2 October 2014

**RE: Section 75W request to modify the approved Project Application
MP11_0091 MOD 2 for Blocks 6 and 7 at Central Park, Chippendale (former
Carlton United Brewery site)**

Christopher Corradi
Area Planning Manager

GROUND FLOOR PLAN
1:100

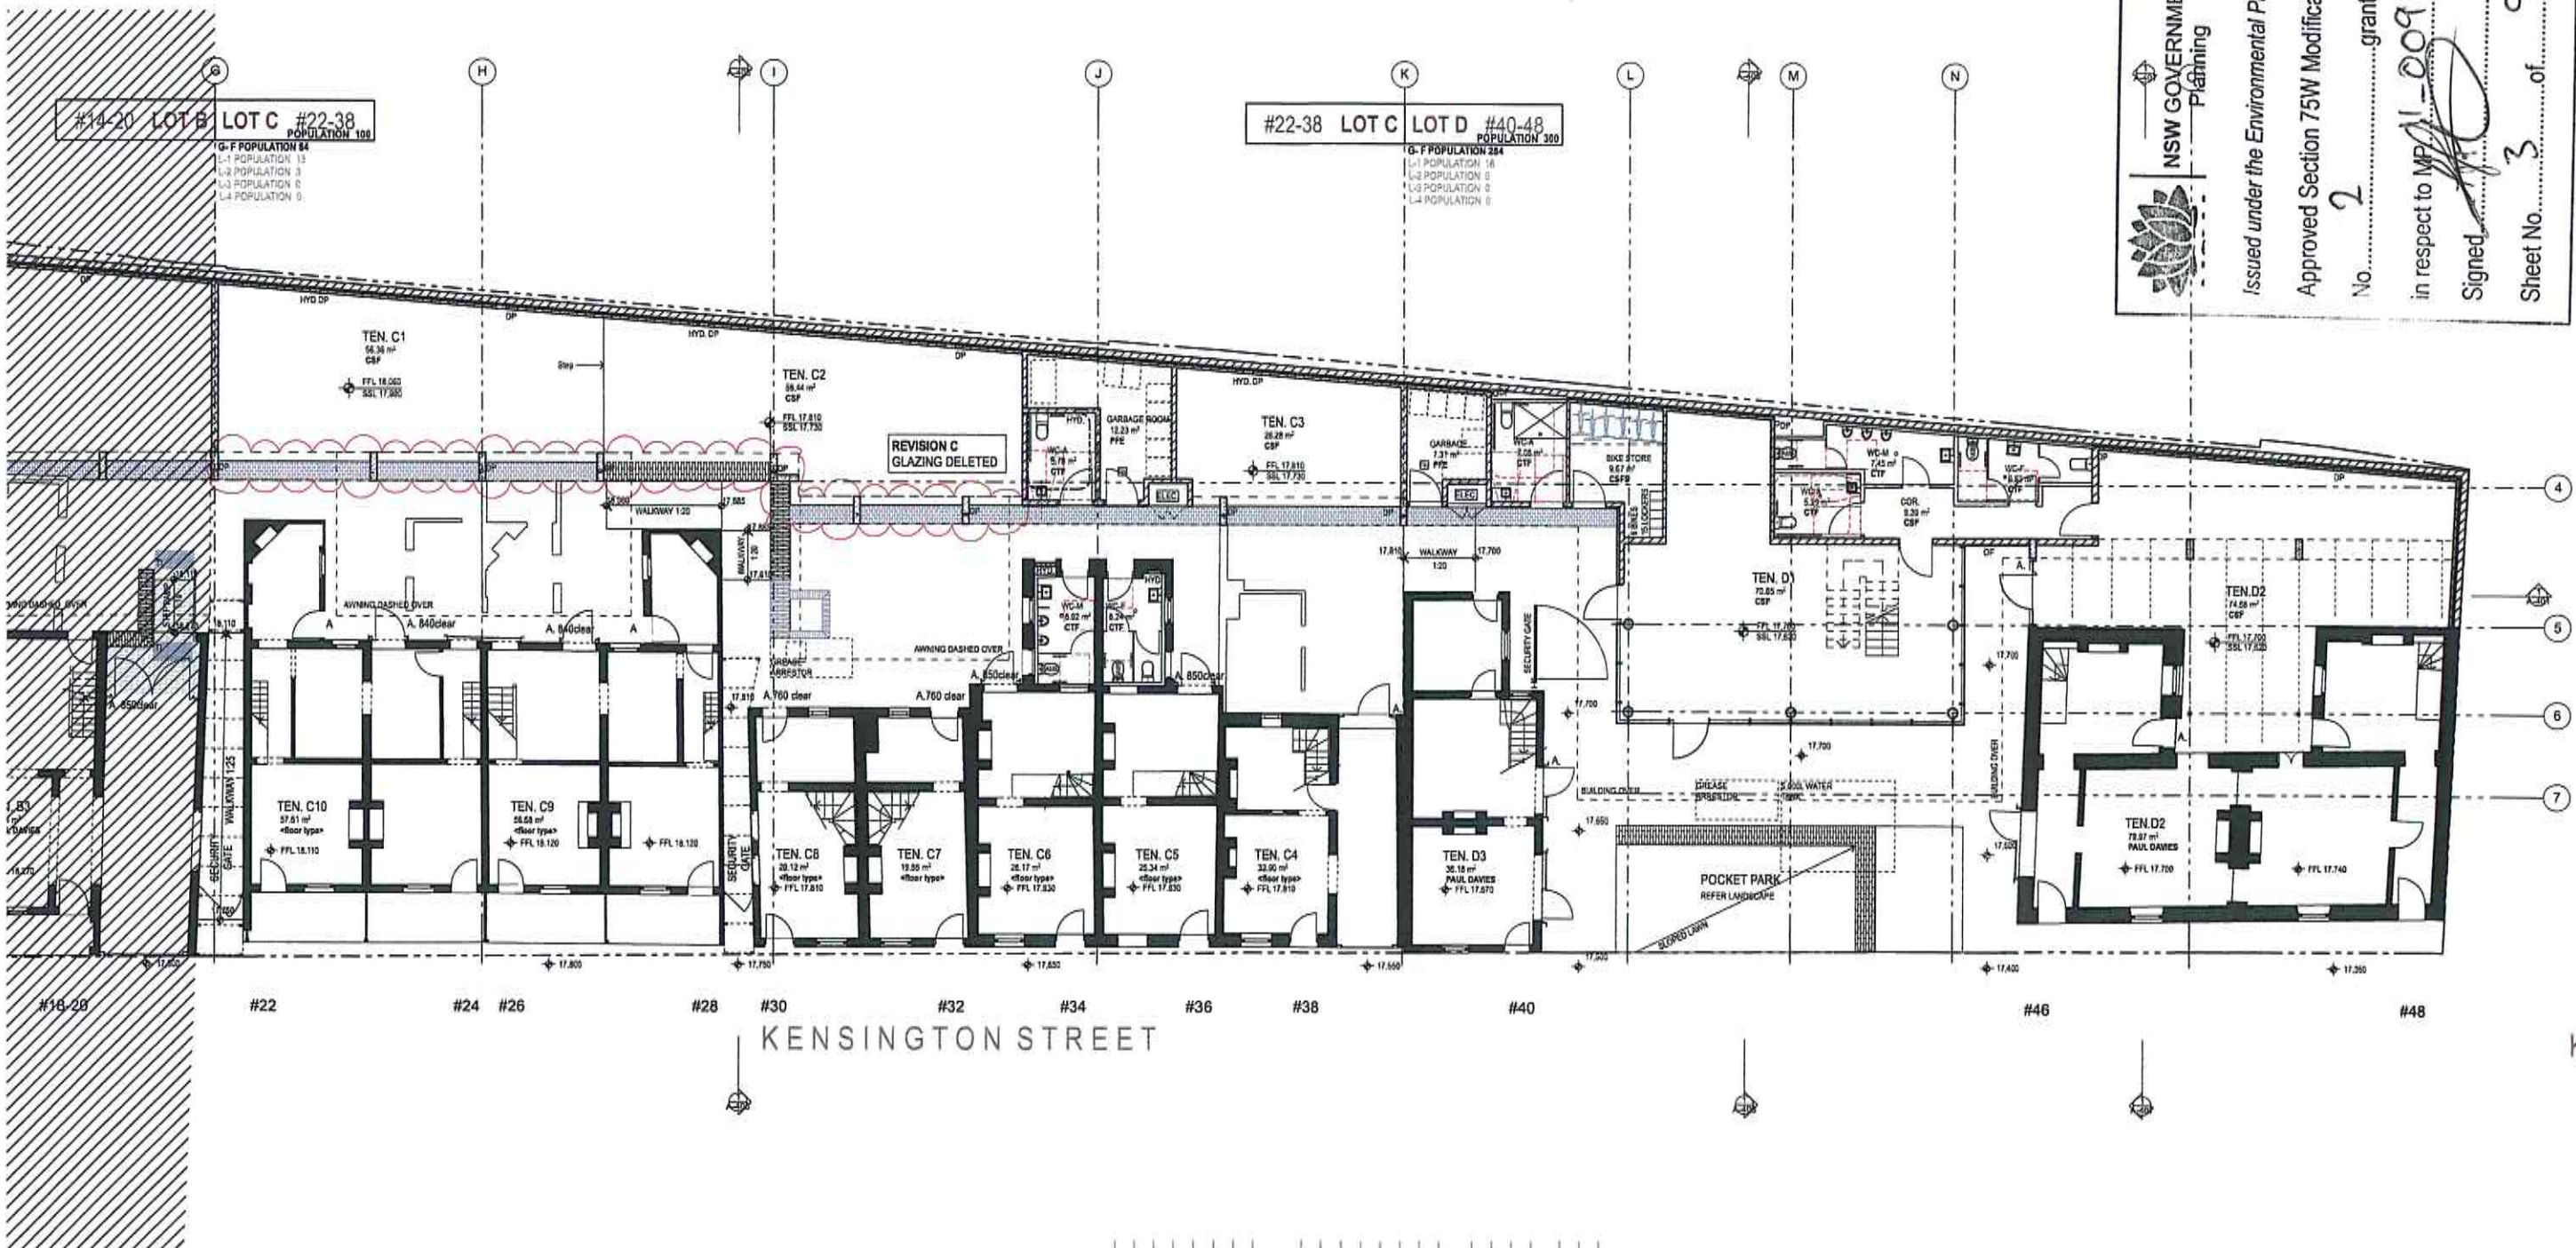
The removal of the glazing will result in the affected tenancy being located within an open undercroft. Concern is raised that this could have an impact upon the security of the site, and could attract trespassers onto the property. Not only does this reduce the overall security of the site, it also poses an unacceptable vandalism risk to the terraces fronting Kensington Street, which are items of local heritage significance.

Concern is also raised that removal of the glazing may result in additional acoustic impacts. The application is not supported by an acoustic report and therefore the impact cannot be assessed. In accordance with Condition A9 'Use – Separate DA', a separate future DA will be required for the fit-out and use of the tenancy. If acoustic criteria cannot be met at that stage the operator will not be permitted to trade past 10.00pm.

The above concerns can be addressed by condition of consent.

LEVEL 1 FLOOR PLAN
1:100

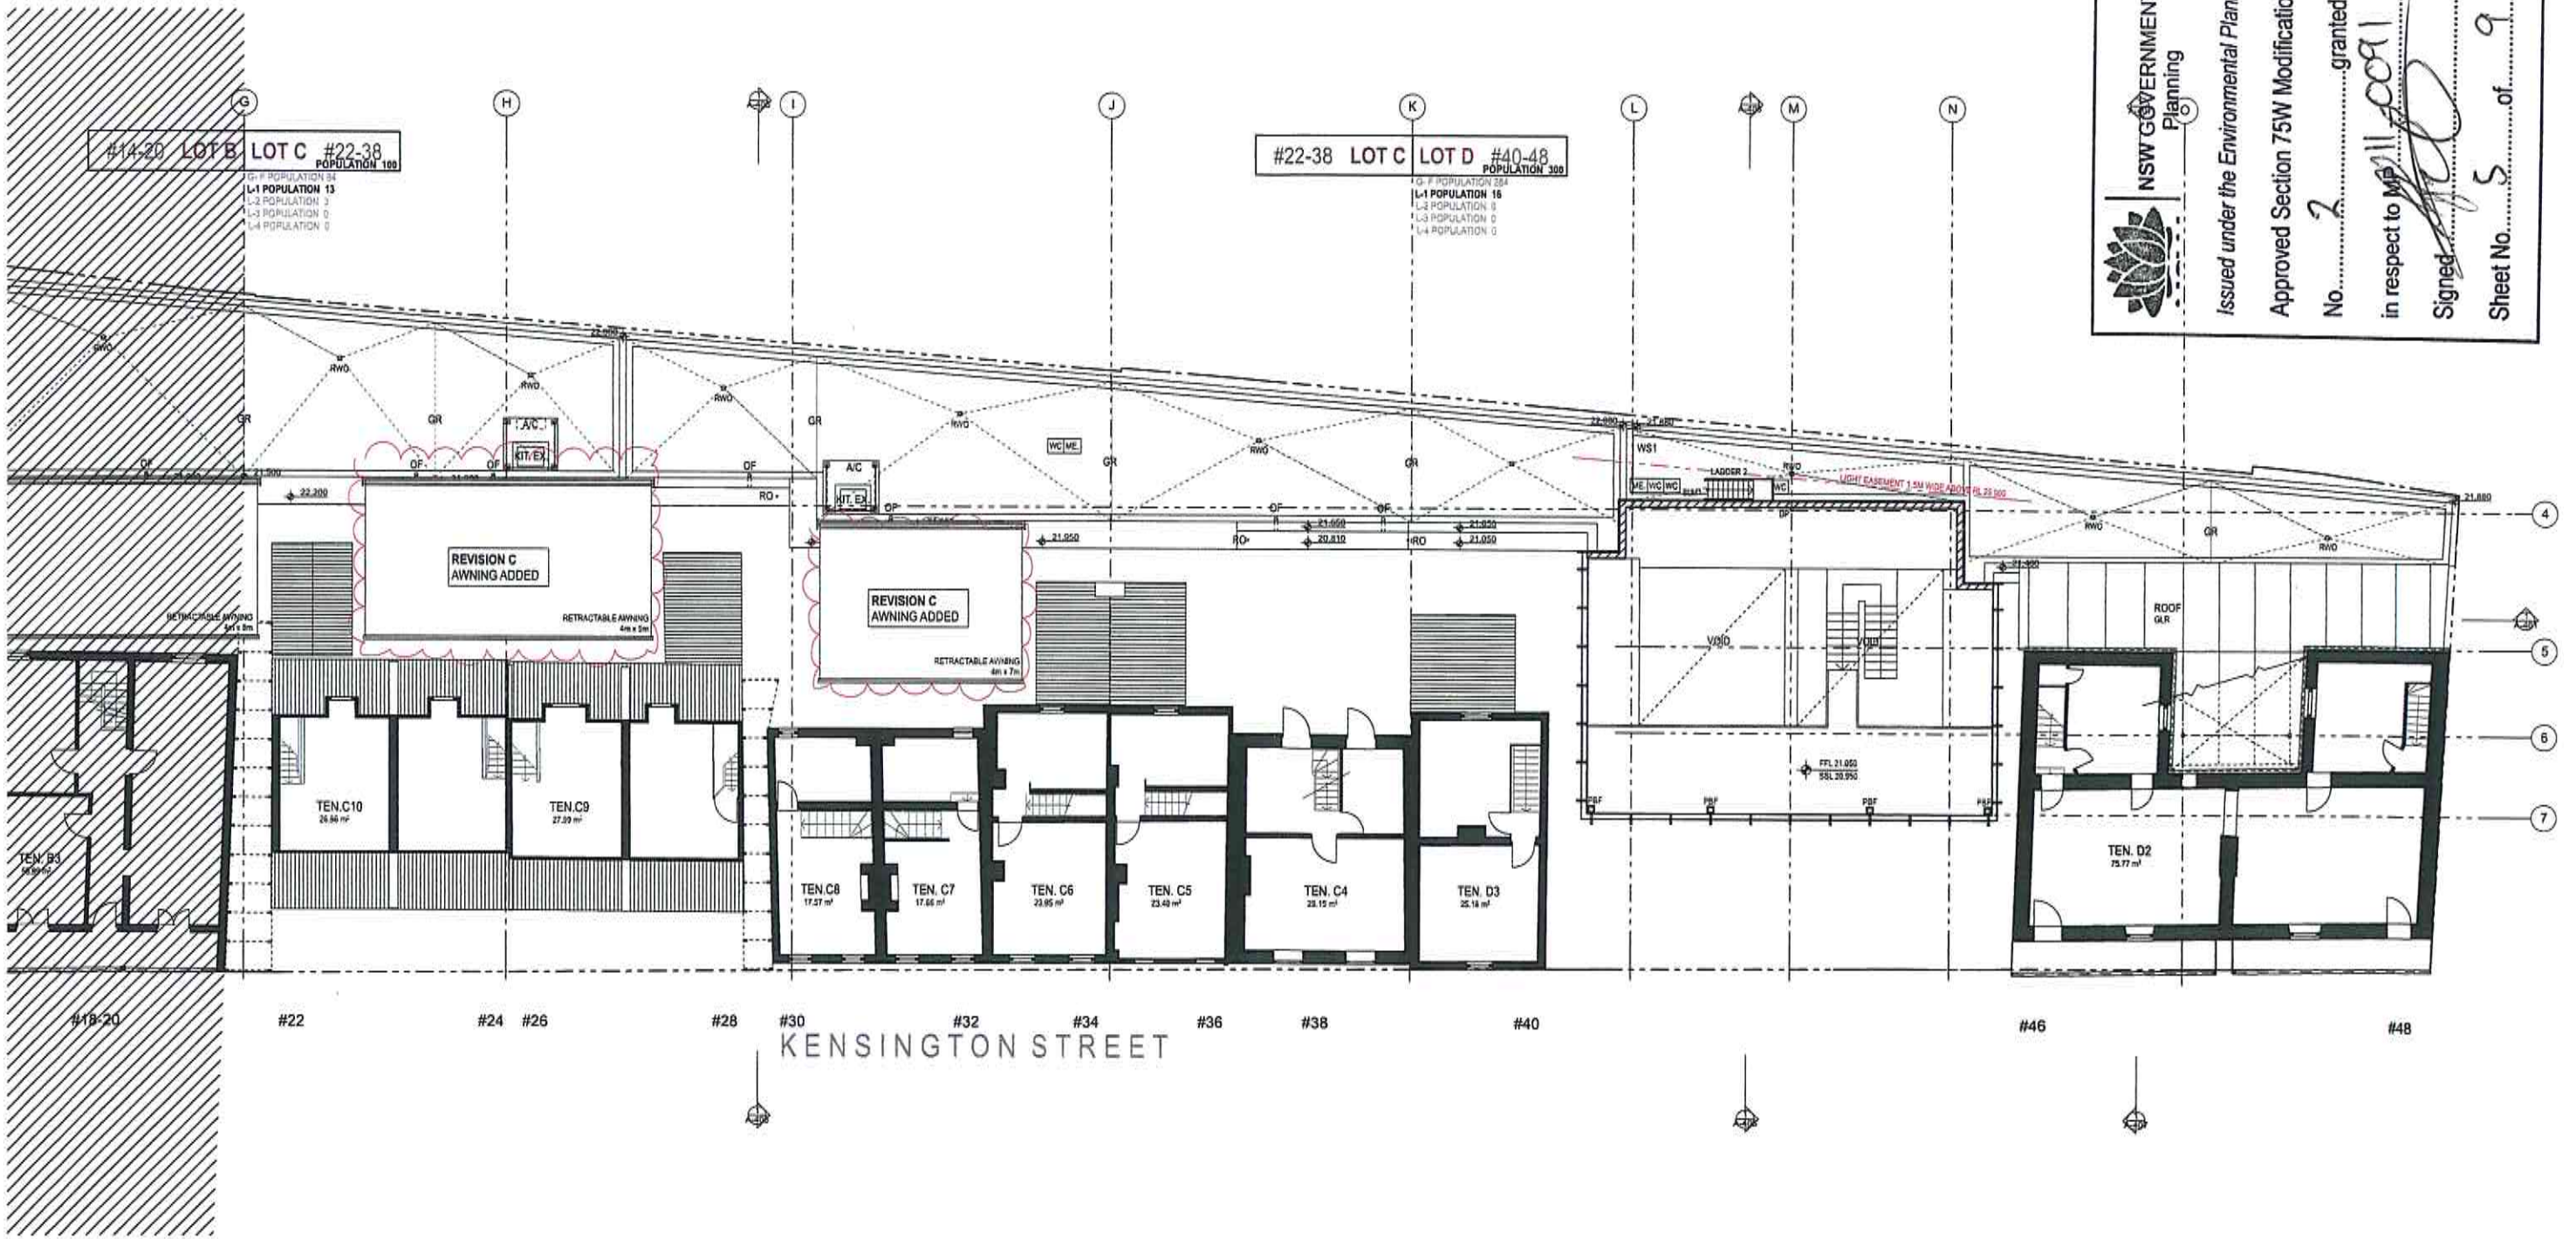
Notwithstanding this, additional concern is raised with these awnings, as they canopy extend further than those that were originally proposed and are also situated closer to the rear building line of the heritage items. It is recommended that the awnings are set back behind the rear wings of the terraces to respect the heritage curtilage of those buildings.
